Re: Kingley Gate Development, Phase 2 Courtwick Lane, Land South of Railway Station, Littlehampton.

Thank you for your correspondence of the 13th March 2014 advising me of an application for the approval of reserved matters for the 182 units of Phase 2 for the development at the above location, for which you seek advice from a crime prevention viewpoint.

Phill Edwards
Crime Prevention Design Adviser
Sussex Police Headquarters

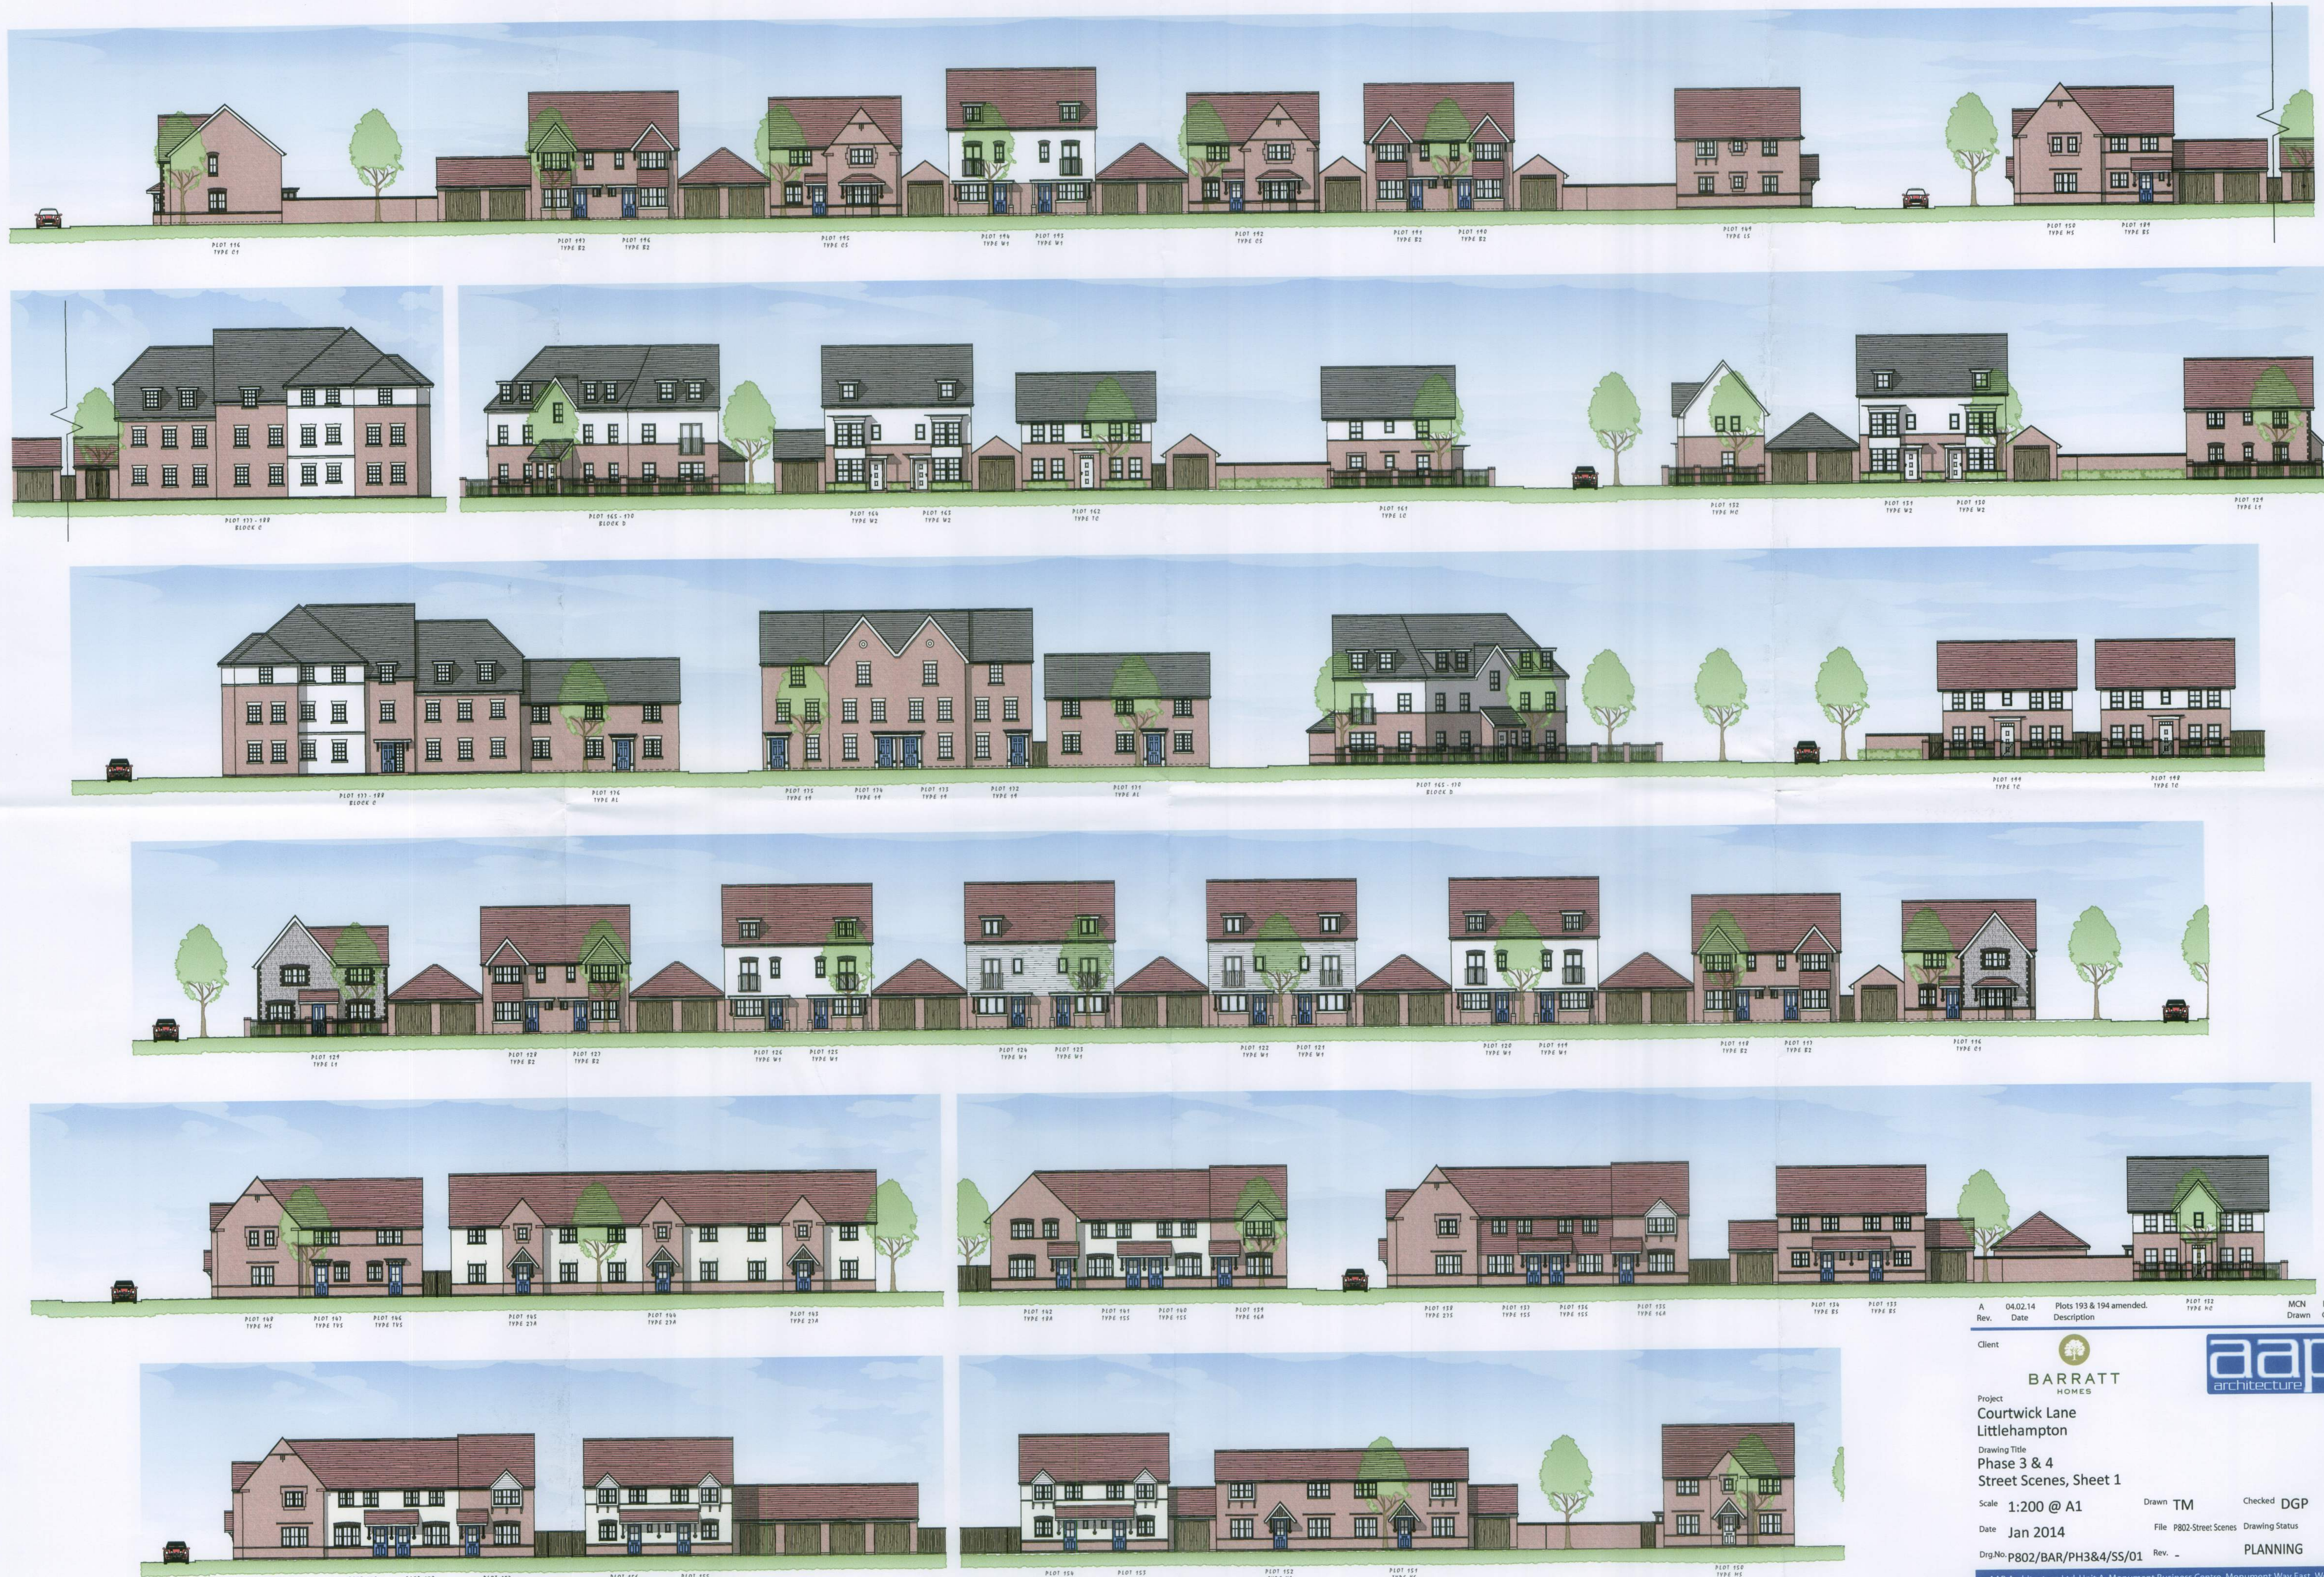
There are two rear parking courts where any cars parked would be unobserved along with a number of rear access pathways to the rear gardens. In both cases a combination of 1.5 metre high close board fencing topped with 300mm of trellis will provide observation into an otherwise unobserved area.

Between plots 261 & 262, I note there is a proposed demarcation fence 1.8 metres high which separates the access to the rear gardens left and right. I feel that this unnecessary and will create a claustrophobic dark environment and could alienate neighbours. A solution would be to keep it gated at the front of the building and have a wider passage leading to the gates of the rear gardens of each property whilst still maintaining the garden fence height of 1.8 metres. Or alternatively have a small dividing fence of 1.2 metres high between the two dwellings, maintain levels of light and space promoting neighbour community relations.

The northern most LAP has very good surveillance over it; however the southern version is ringed on 3 side by parking bays which reduces the natural surveillance from the surrounding dwellings. Due to the close proximity of the parking bays and manoeuvring areas to the southernmost LAP, I recommend that this area has railings installed around it as is shown for the Northern most LAP.
